Consultation Response from KC Highways		
2019/92221 Kenmore Caravans Ltd, 119, Huddersfield Road, Mirfield, WF14 9DA		
Outline application for demolition of existing buildings and erection of Class A1 retail unit, access, car parking, servicing, landscaping and associated works		
Date Responded: 31/03/2020	Responding Officer: Mark Berry	Responding Ref: 10-5NE-01
This application seeks outline approval for demolition of existing buildings and erection of Class A1 retail unit, access, car parking, servicing, landscaping and associated works (all matters reserved other than access) at Kenmore Caravans Ltd, 119, Huddersfield Road, Mirfield. The highways consultation response dated 23rd August concluded that this application provided insufficient information as follows: 1, The application is supported by a Transport Assessment (TA) prepared by Turner, Lowe Associates. The scope of the Transport Assessment was not agreed with Highways Development Management, and did not include capacity analysis of the Doctor Lane and Stocks Bank Road junctions and the Huddersfield Road and Station Road signalised junction. The TRICs data was not included with the TA and the traffic generation figures qu

Proposed Development
Huddersfield Road.
Mirfield.
Service Vehicle
Manoeuvres

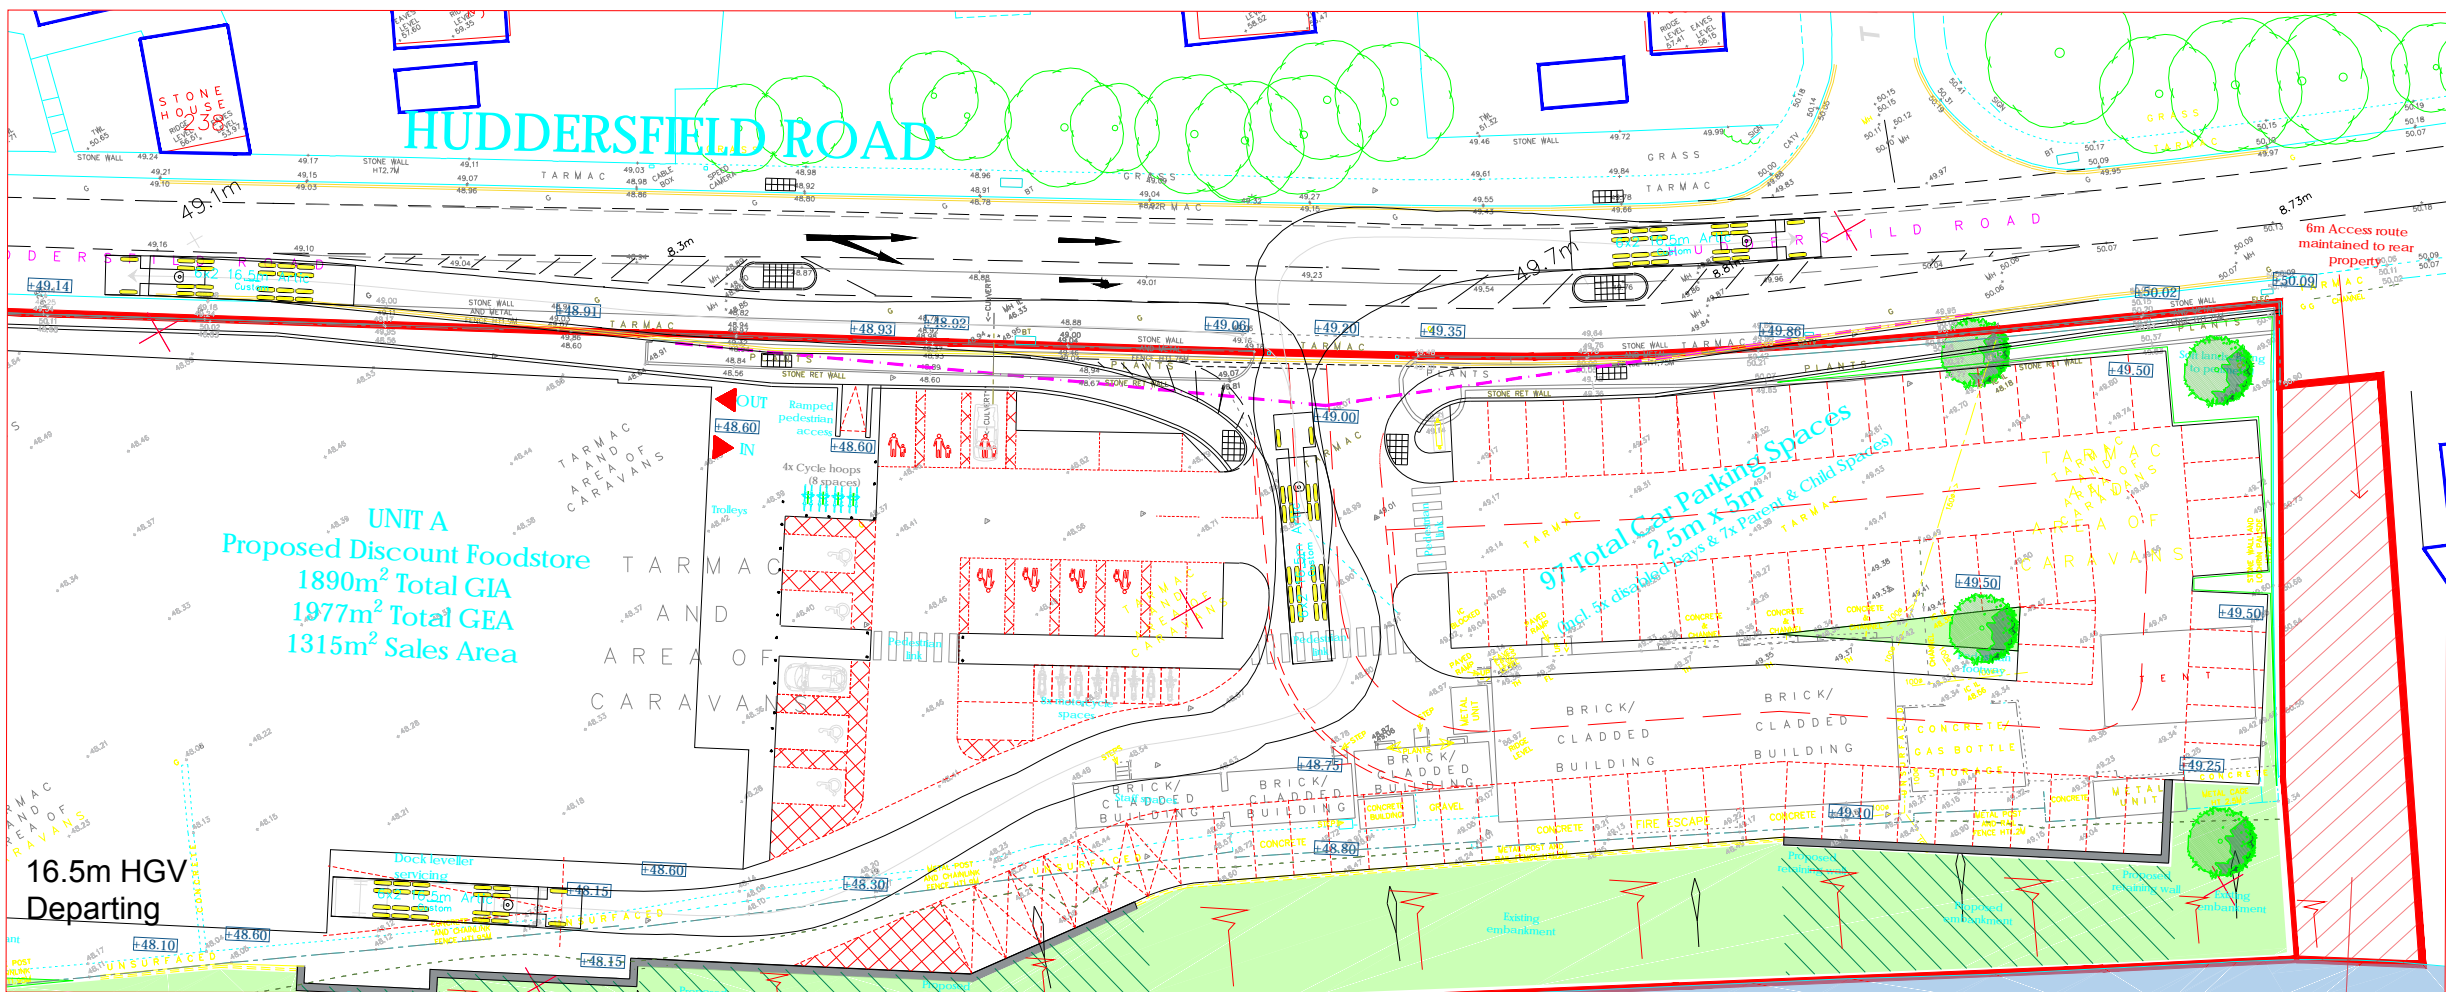
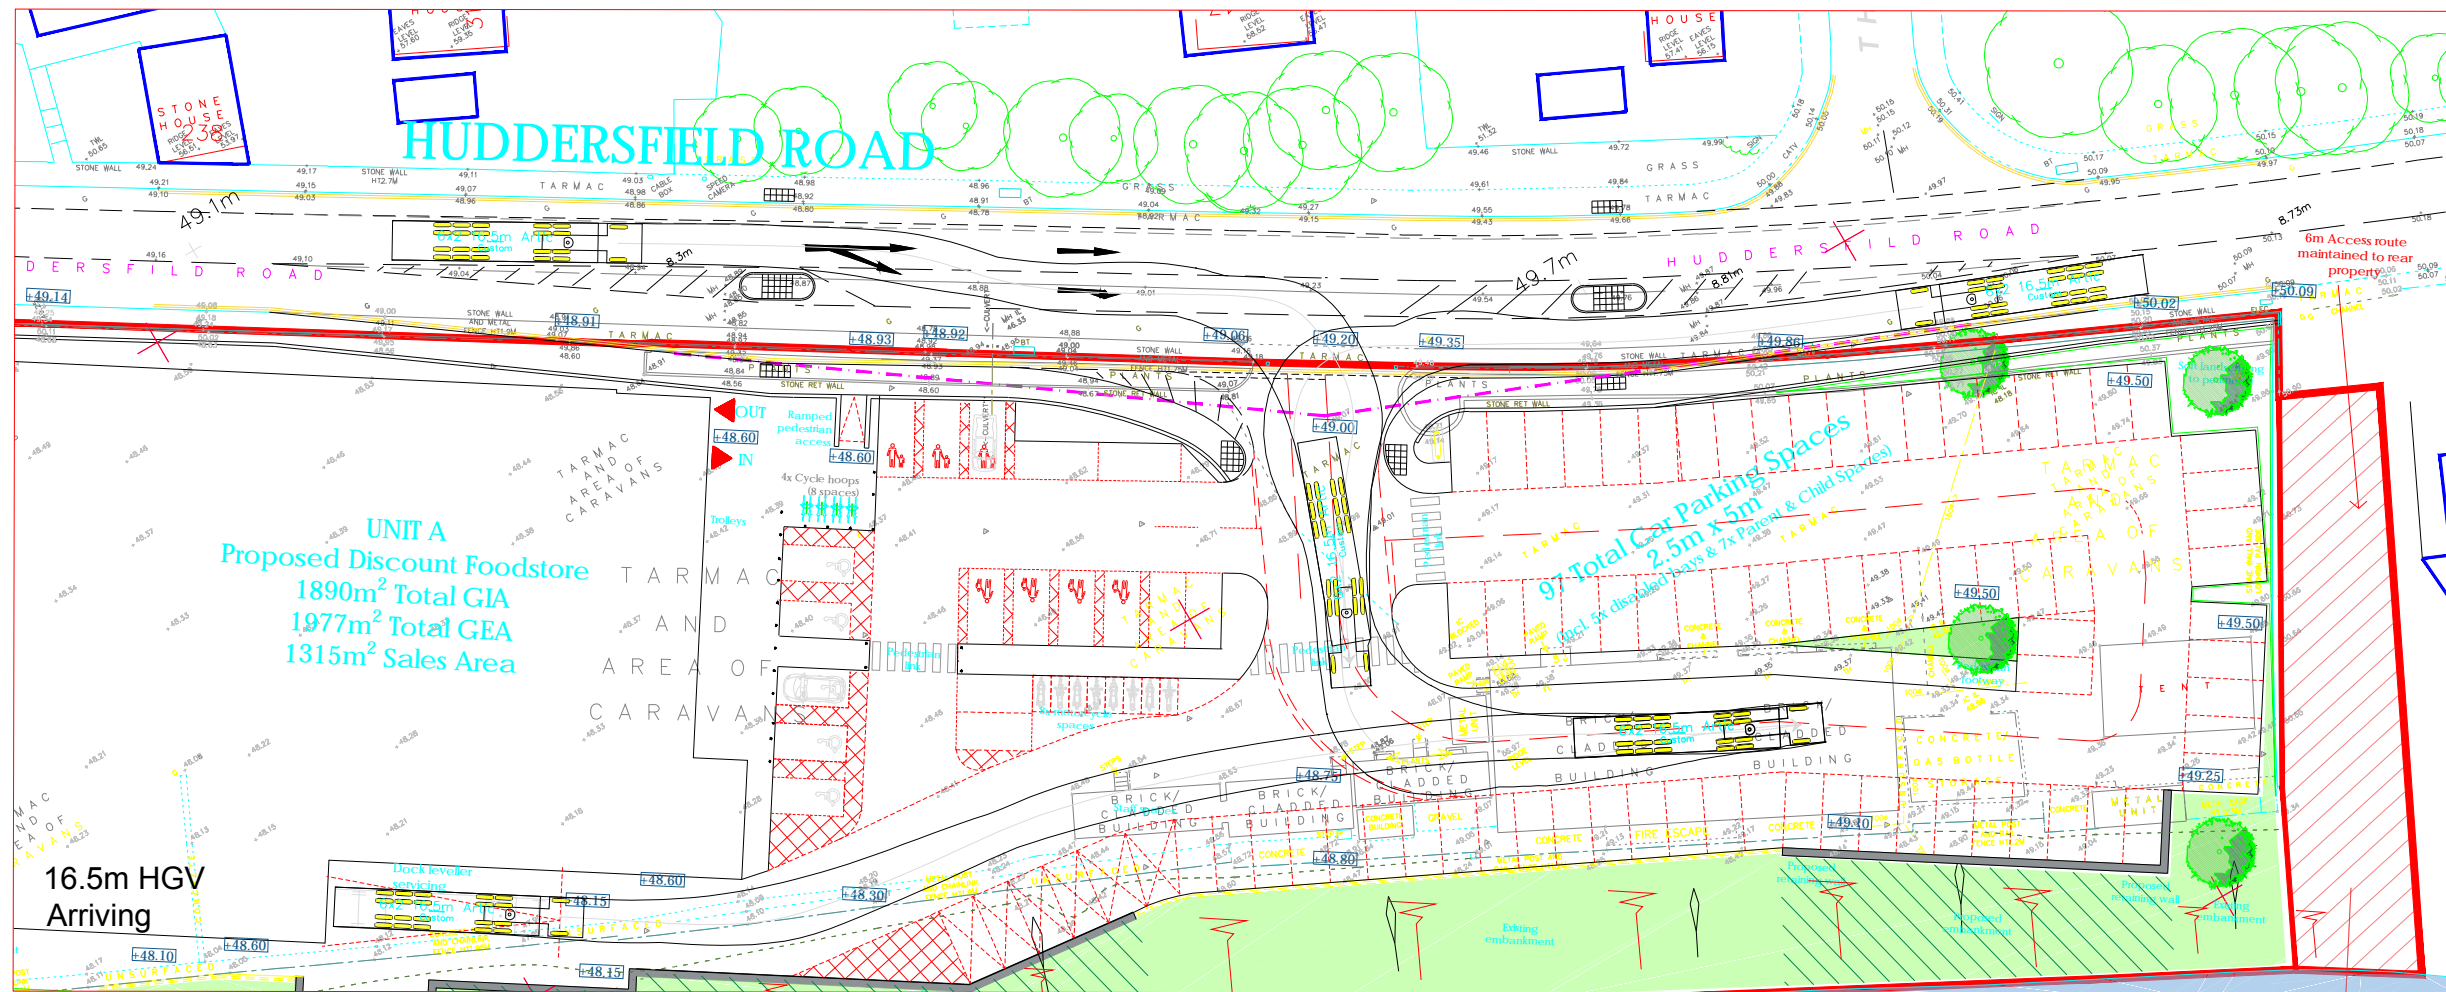
The extent of the 30mph speed limit along this section of Huddersfield Road is shown to be extended to include the access to the proposed store, the visibility requirements on to Huddersfield Road are shown based on the reduced speed limit, acceptable swept paths for a 16.5m articulated vehicle are provided and motorcycle and cycle parking is shown on the revised plans.
